Gwandalan/Summerland Point Action Group Inc

4th February, 2011

Re: **Gwandalan residential subdivision Project Application MP 10 – 0205**

**Longitudinal Section - Road 5**

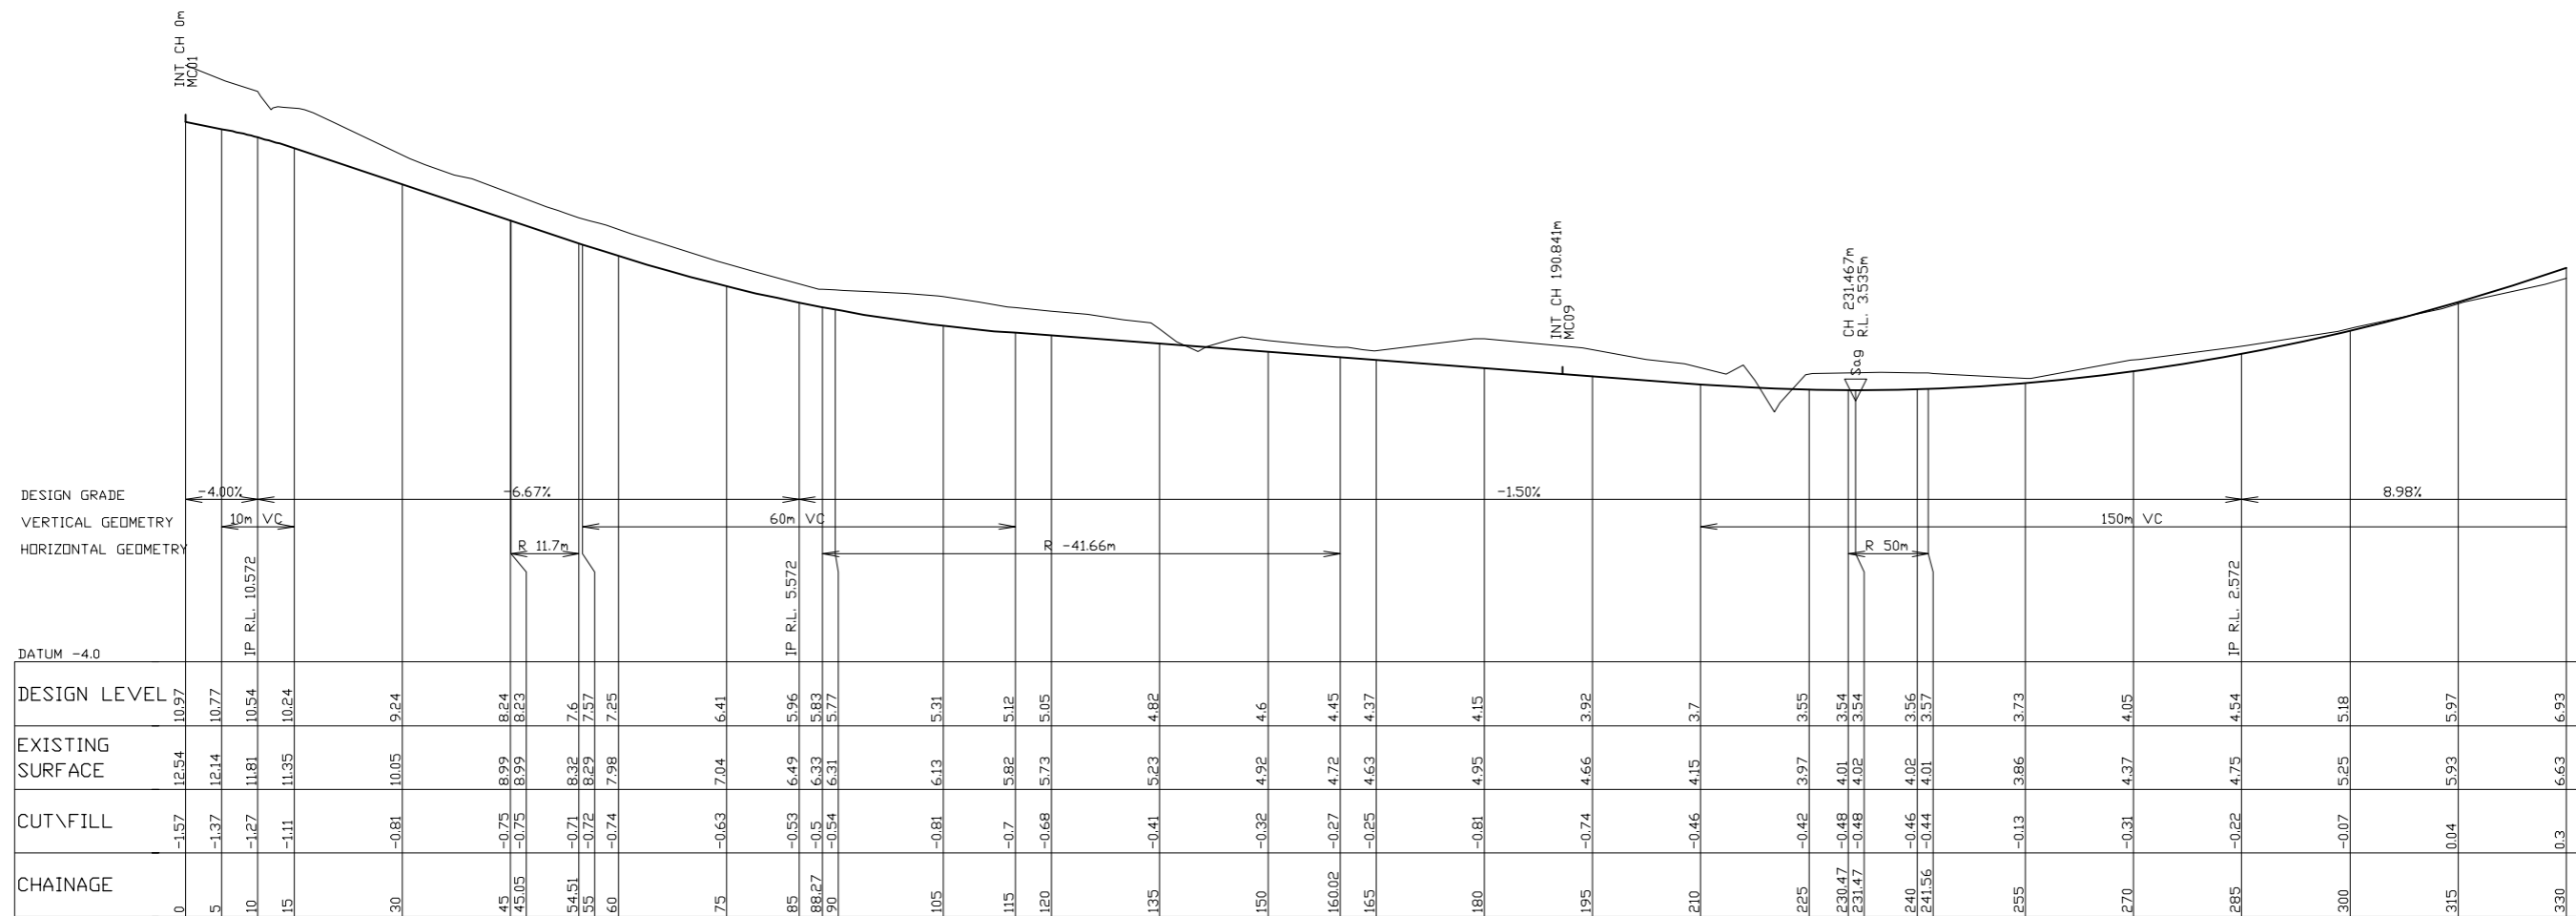
Road 5 is a 6m wide laneway which runs at the back of houses in Kanangra Drive. We are not sure if these houses will face the Laneway or Kanangra Drive. If they face the Laneway they will overlook the backyards of the homes opposite which we assume will face Road 4. We believe this laneway would be a security risk to homes on Roads 4 and 5 and it would be a better option to have a slip road along the fence line with houses facing Kanangra Drive and the lots back to back. If they are already to face Kanangra Drive as suggested in the Development Control Plan then access would be via their backyards and housing plans would need to be done accordingly.

Stormwater Catchments			
Council:	Wyong	Projection:	M.G.A.
Datum:	A.H.D.	North Direction:	Grid
Source:	ADW Survey	Plan By:	MJH
Contour Interval:	1.0m (Des & Nat)	Checklist:	MJH

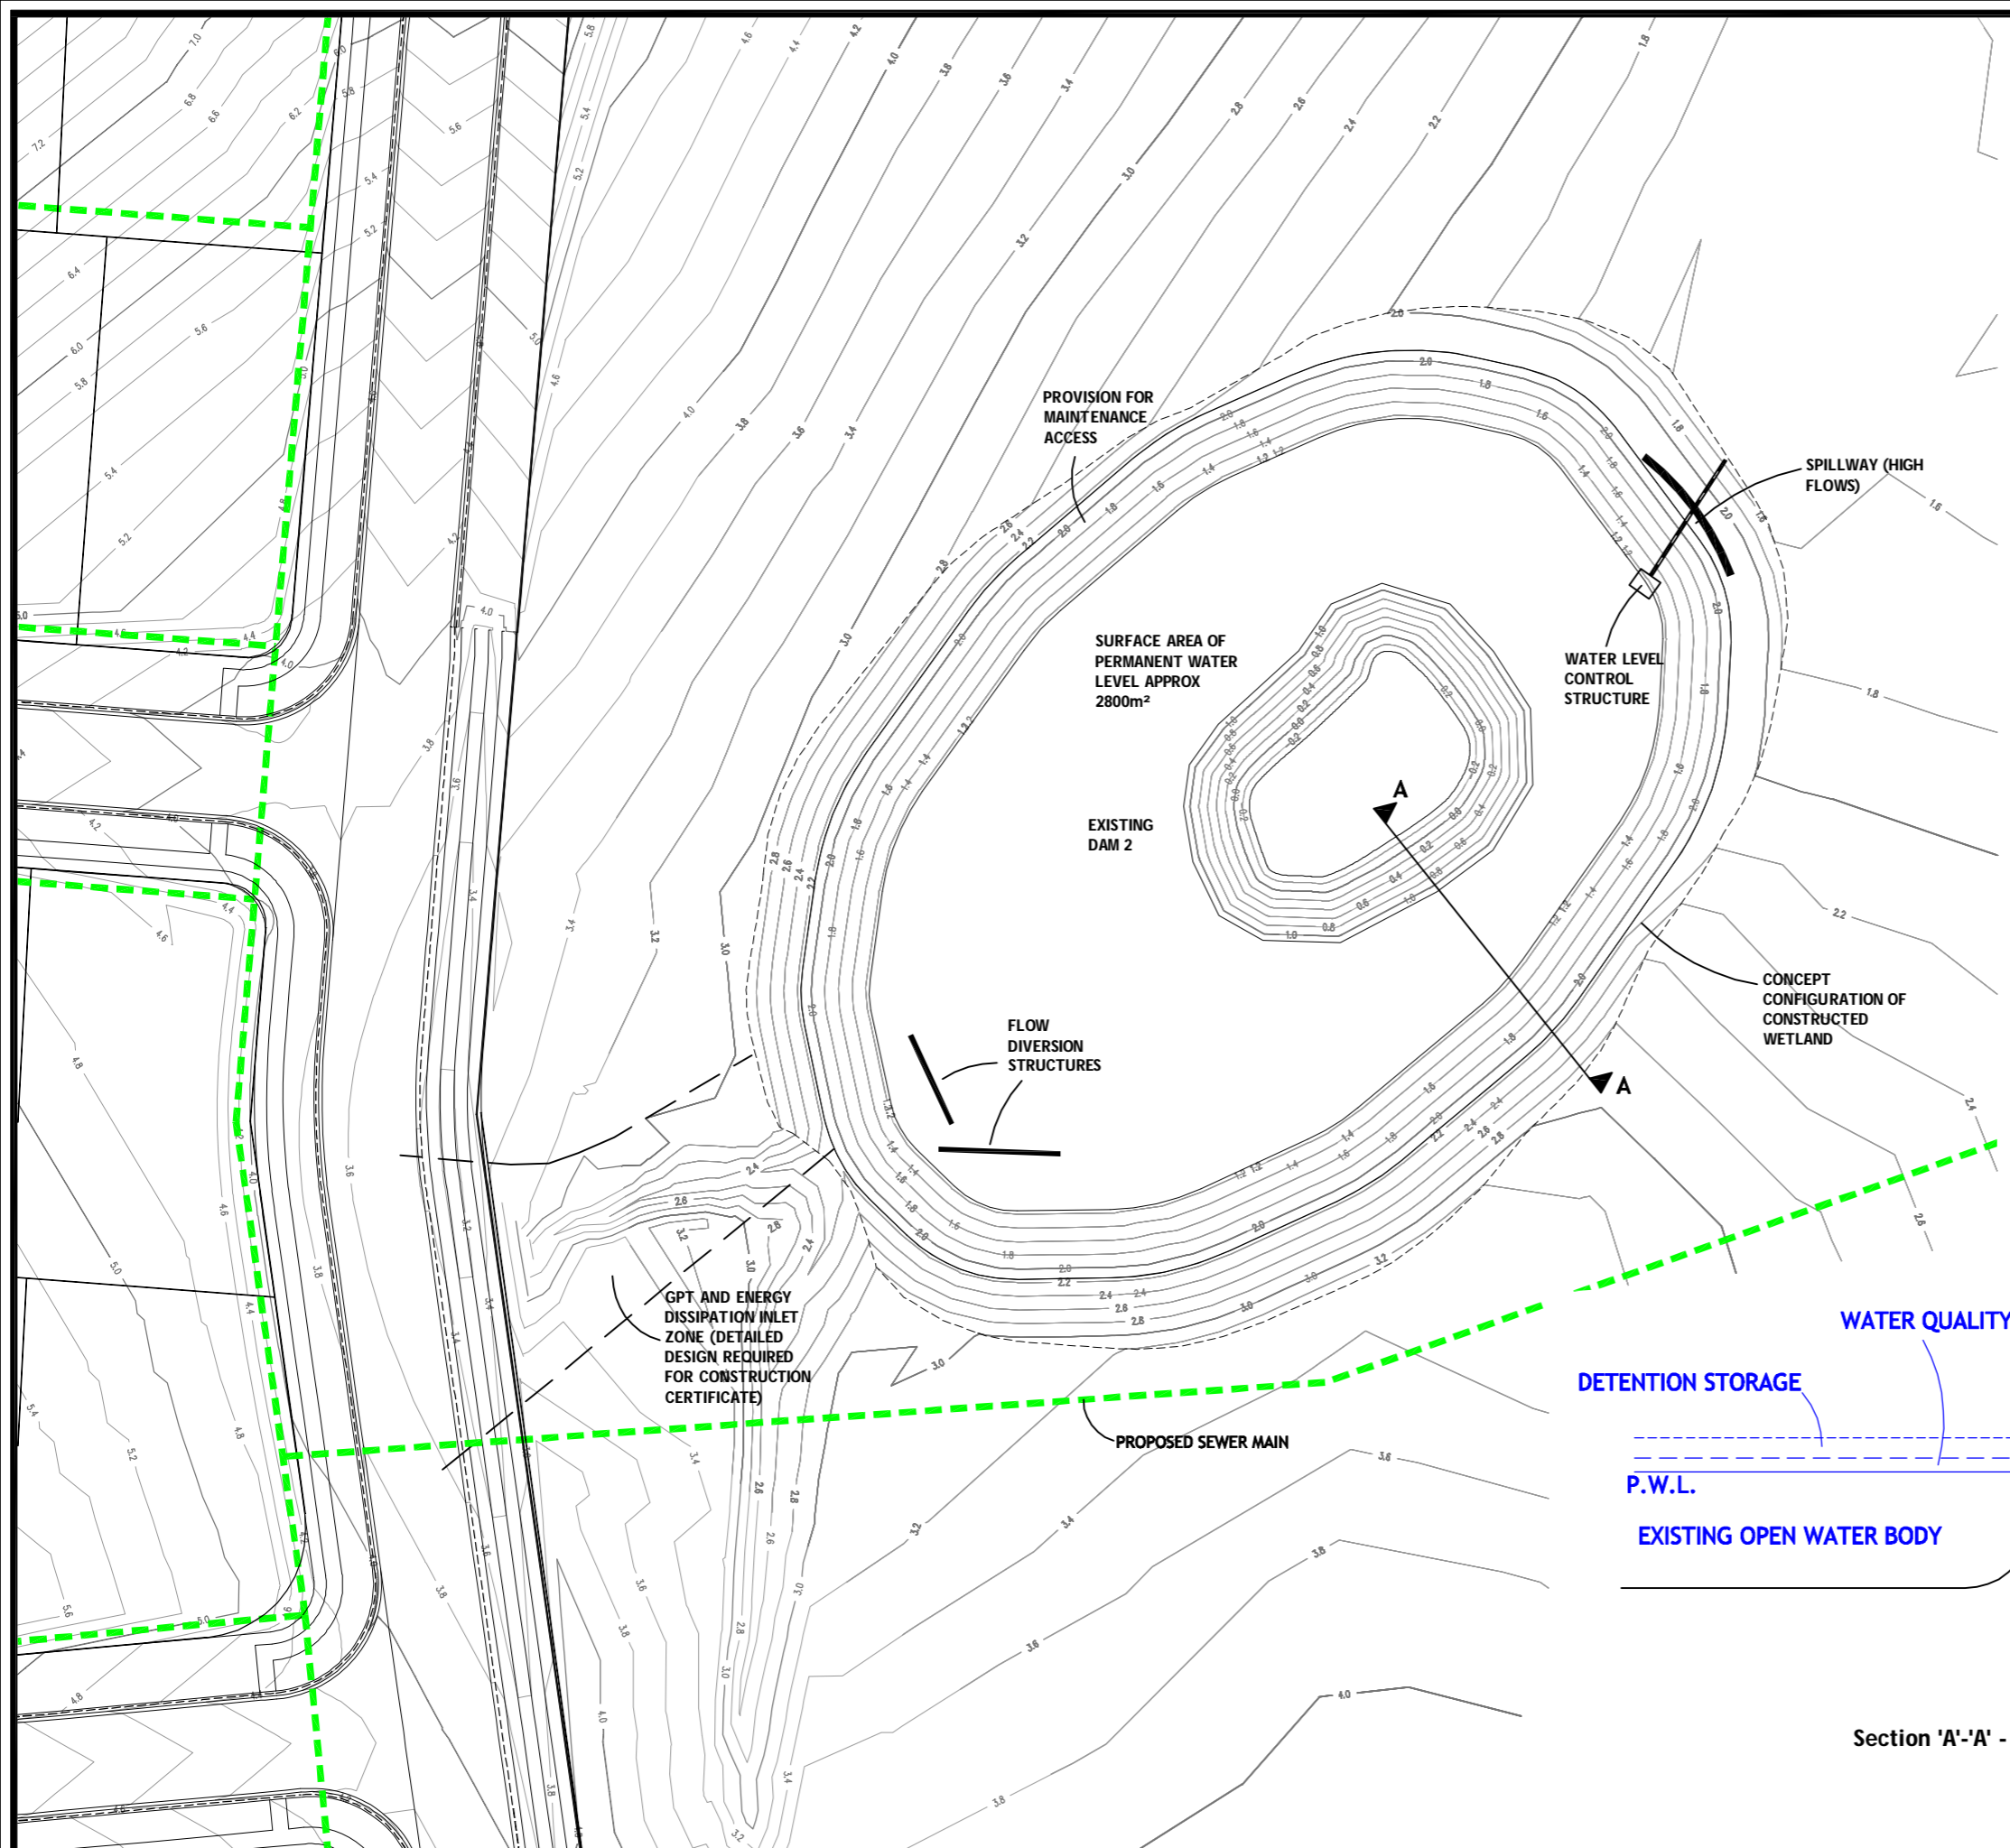
In the stormwater management report it is stated that *the proposed constructed wetland will be a feature for surrounding residents*. Does this mean that the area will be open to the public as say a picnic area? What are the safety issues around this?

This wetland is to be constructed on land which is zoned 7B Environmental Protection and owned by the proponent. Who will maintain the wetland area and is access to be readily available? What would happen if the land is sold and ownership changes? Is it legal / acceptable to have the drainage going into Environmentally protected areas?

Figure 7 Access and circulation

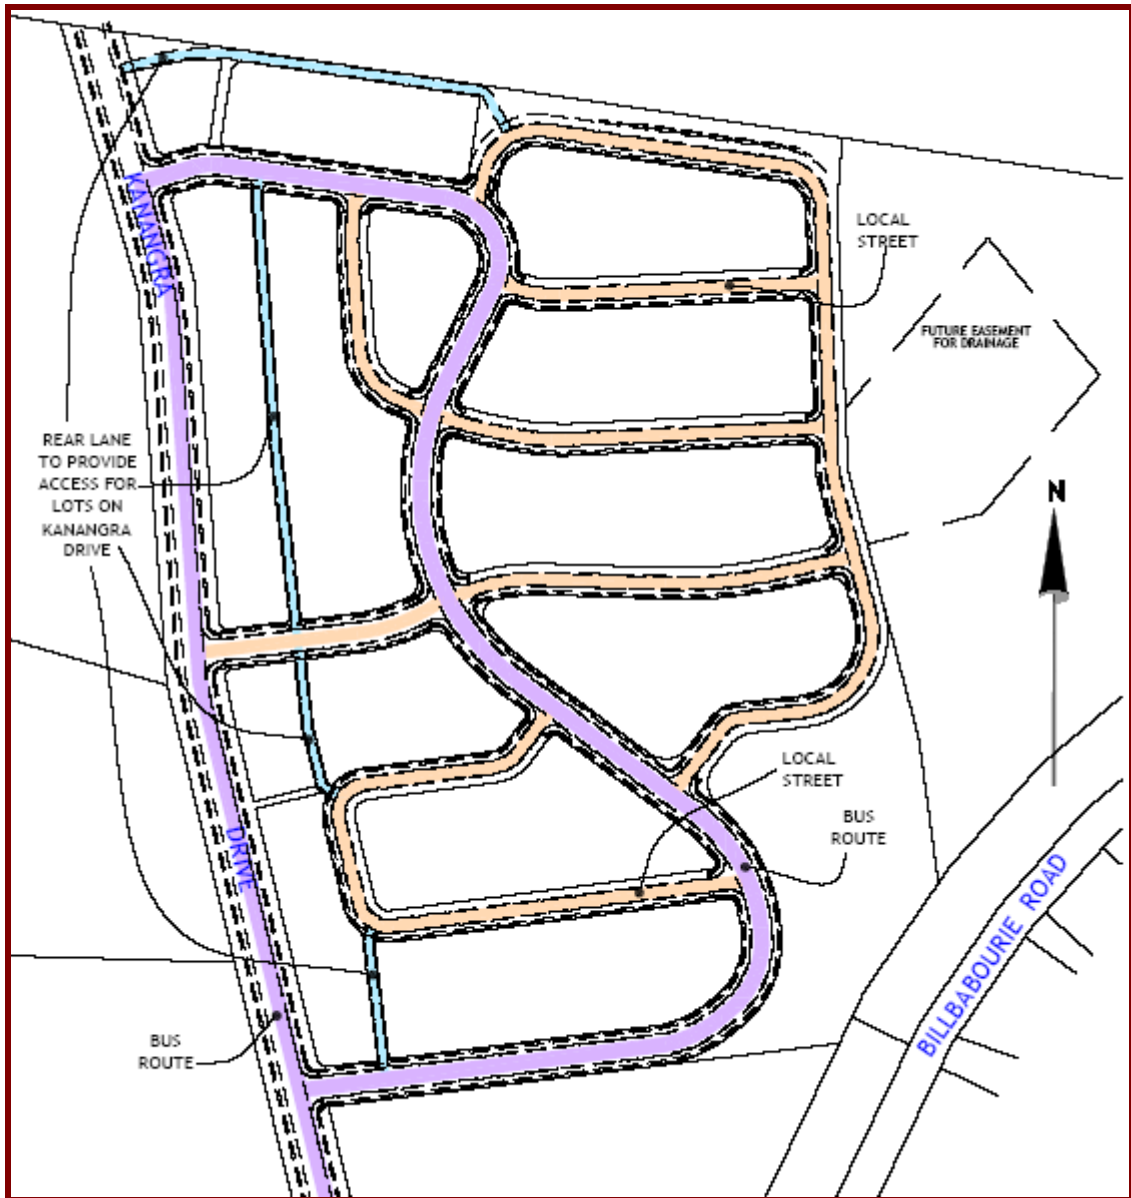
There is no link between this development and the current homes in Gwandalan. This area is completely isolated from the main area of Gwandalan and this concept plan shows the only access being via the 3 accesses to Kanangra Drive which then means all traffic has to go past the school and through the intersection at Orana Avenue.

It would be sensible if access (pedestrian and bicycle) could be obtained through one of the residential properties fronting Billabourie or Garema Roads. This would also give current residents a reason from visiting the new area. (This may require the purchase of a property.)

Figure 9 Subdivision staging

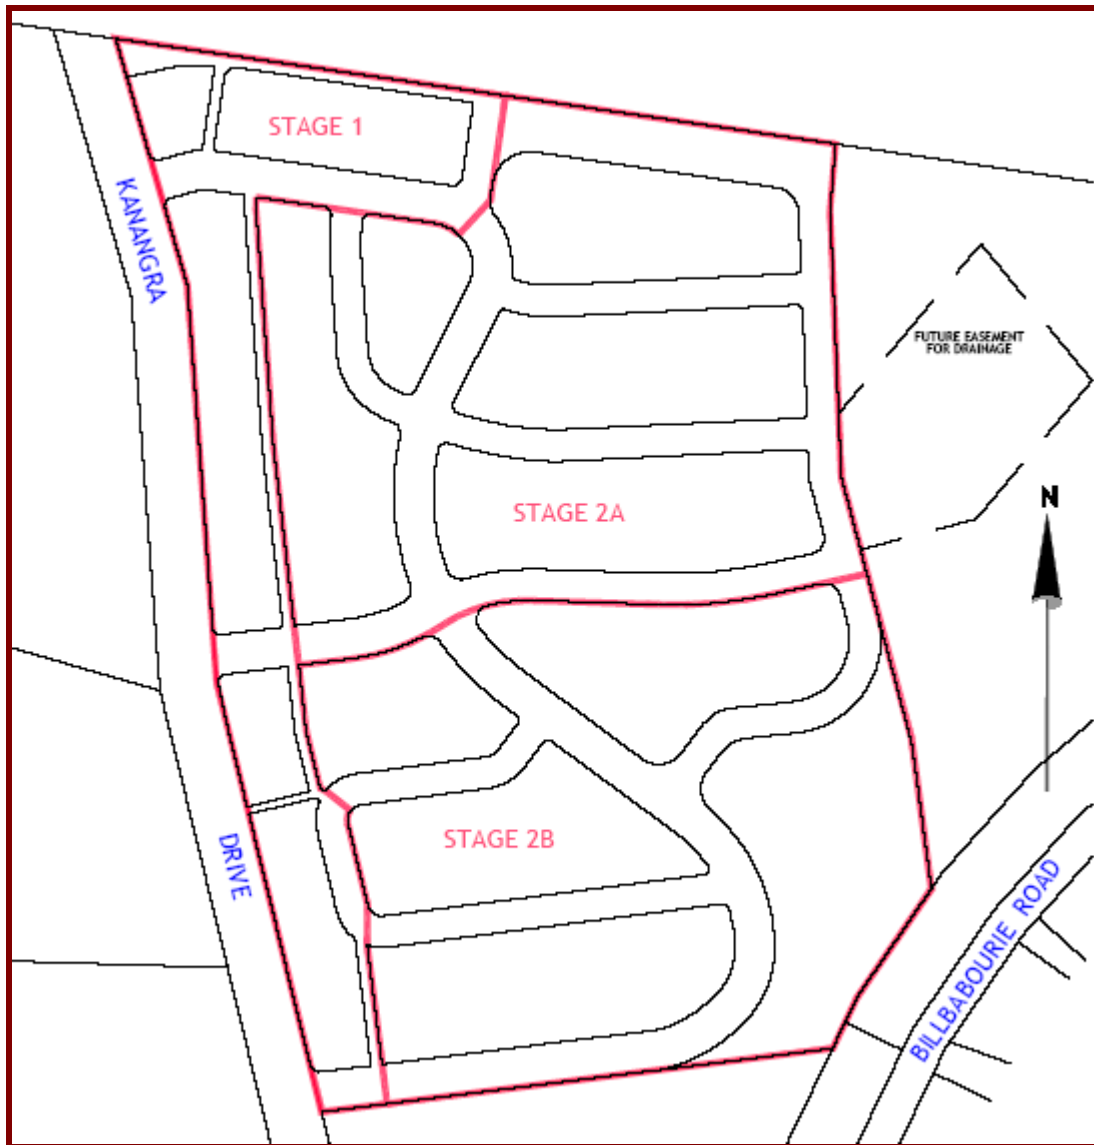
The concept plan shows 3 stages, with stage 3 being for future development. Does this mean that the developer is unsure how well these lots will sell?

We believe that Stage 1 should be in the Southern part of the estate, not along Kanangra Drive and the border to Point Wolstoncroft. This northern area is very remote from the rest of Gwandalan with no other homes in the area. It is essential that the clearing of bushland should also coincide with the staging so that large tracts of bushland are not cleared at one time.
